Drax Bio-Energy and Carbon Capture Storage
Deadline 2 – Responses to ExA's Written Questions

Michael Reynolds
Senior Policy Officer (Infrastructure)
North Yorkshire County Council

Appendix A

DRAWING TITLE
**FIGURE 18.1:
SHORT LIST OF 'OTHER DEVELOPMENTS'
CONSIDERED WITHIN THE CUMULATIVE
IMPACTS ASSESSMENT
SHEET OF 1 OF 7**

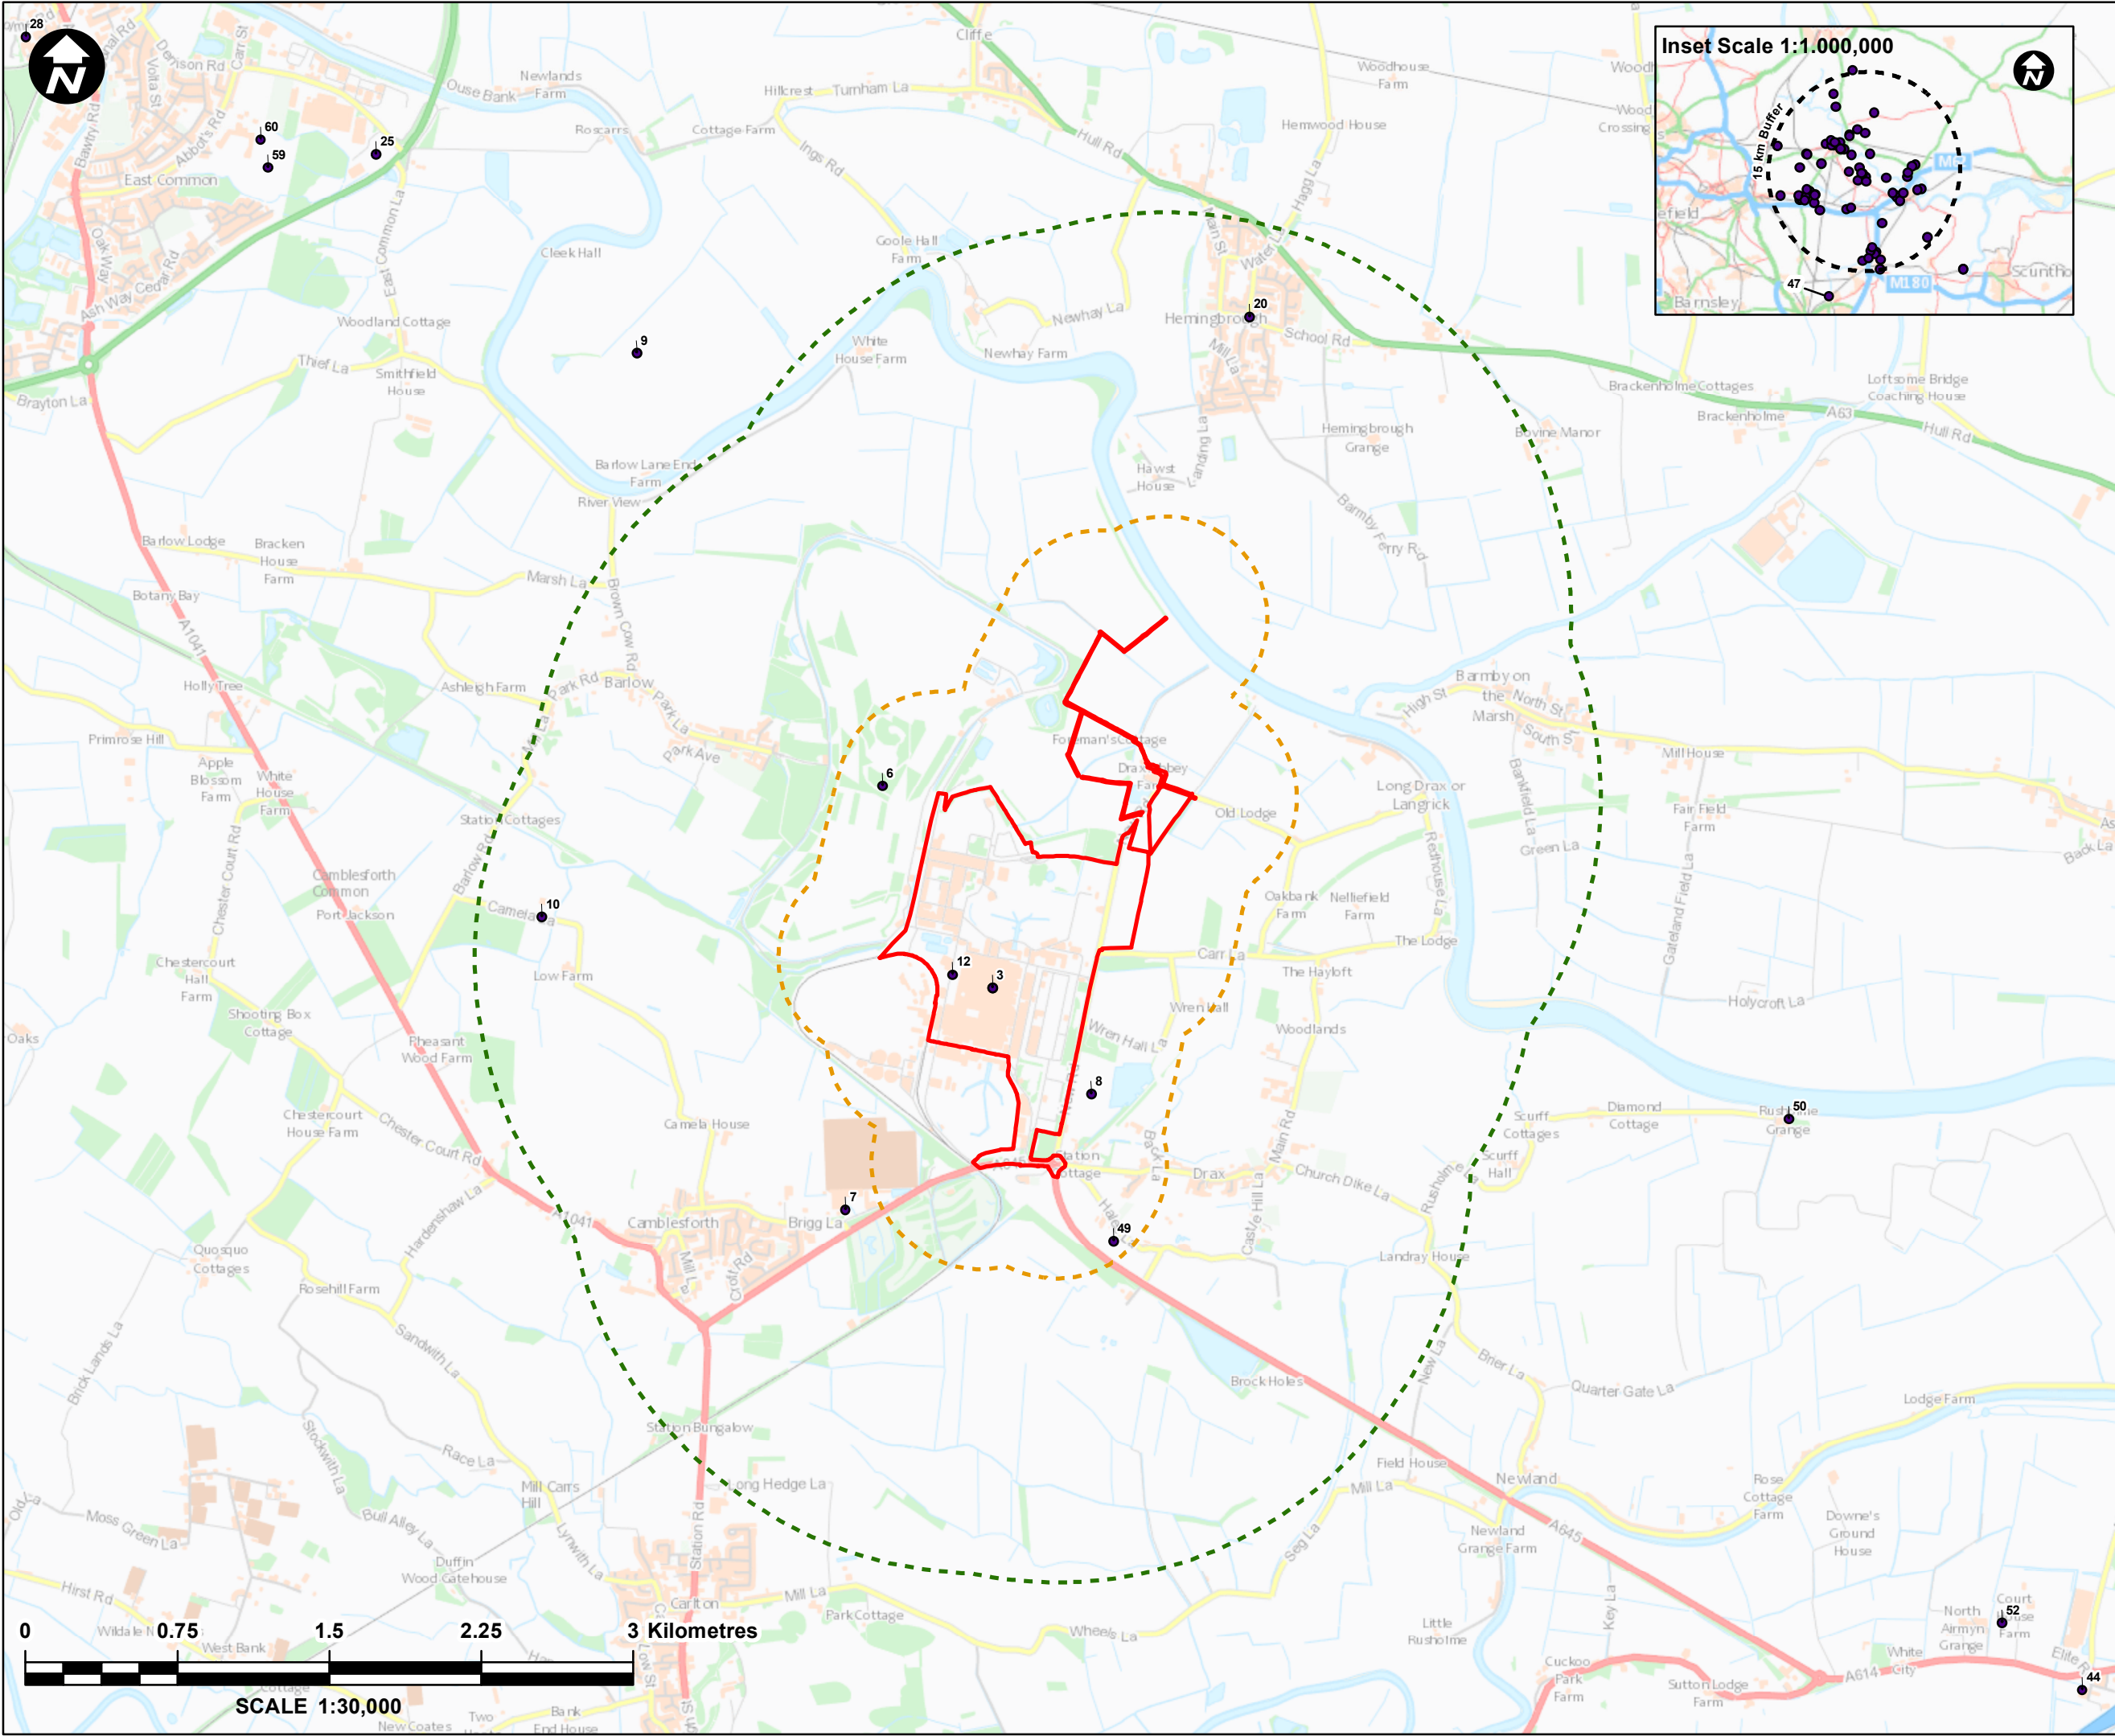
GEN 1.12	Paragraph 18.5.38 of ES Chapter 18 [APP-054] states that any planning applications published since February 2022 have not been included within the cumulative effects assessment. Could the Applicant and LPAs confirm: i. whether they are aware of any other developments submitted to the local authority/ PINS since this date that should be included in the short list, and whether this is reflected in [AS-013]; and ii. whether any of the other developments in the long list had additional environmental assessment information subsequently submitted that would necessitate inclusion of that development in the short list.	The Applicant has provided SDC with an updated version of the long list and the short list, dated January 2023, which reflects an updated planning application search, which was finalised on 30th November 2022. SDC have provided the Applicant with comments on this and it is expected that the Applicant will be submitting updated versions of the long list and short list into the Examination, which reflects comments made by SDC. For the avoidance of doubt, SDC have only commented on the long list and short list insofar as it relates to developments within Selby District.

GEN 1.19	i. Can the LPA advise of the status of the planning application 21/03027/STPLF listed as short list ID44 in the Short List of Other Developments [AS-013]?	Planning application 21/03027/STPLF listed as short list ID44 in the Short List of Other Developments [AS-013] is located within the East Riding of Yorkshire. However, from a search of the East Riding of Yorkshire's Public Access website, it appears that the planning application was granted permission on 23 rd December 2022, subject to conditions and a S106 legal agreement.
AIR QUALITY AND EMISSIONS		
AQ 1.7	Can the EA and SDC confirm that they are satisfied with the Applicant's approach of undertaking no additional project-specific air quality surveys as per paragraph 6.5.49 of the ES [APP-042]?	The Applicant has opted to do a desk study of baseline data sources to quantify existing pollutant concentrations in the area, rather than undertaking project-specific air quality surveys. Clearly, actual monitoring is more accurate than using prediction sources, however this approach is not uncommon. As part of the wider air quality regime, SDC carries out proactive air quality monitoring of areas thought to exceed the national air quality objectives (NAQO) which shape/define AQMAs. SDC do not have any data relating to Drax, but the atmospheric dispersion modelling shows that they will likely meet the relevant NAQO, so there are no objections to the approach taken.
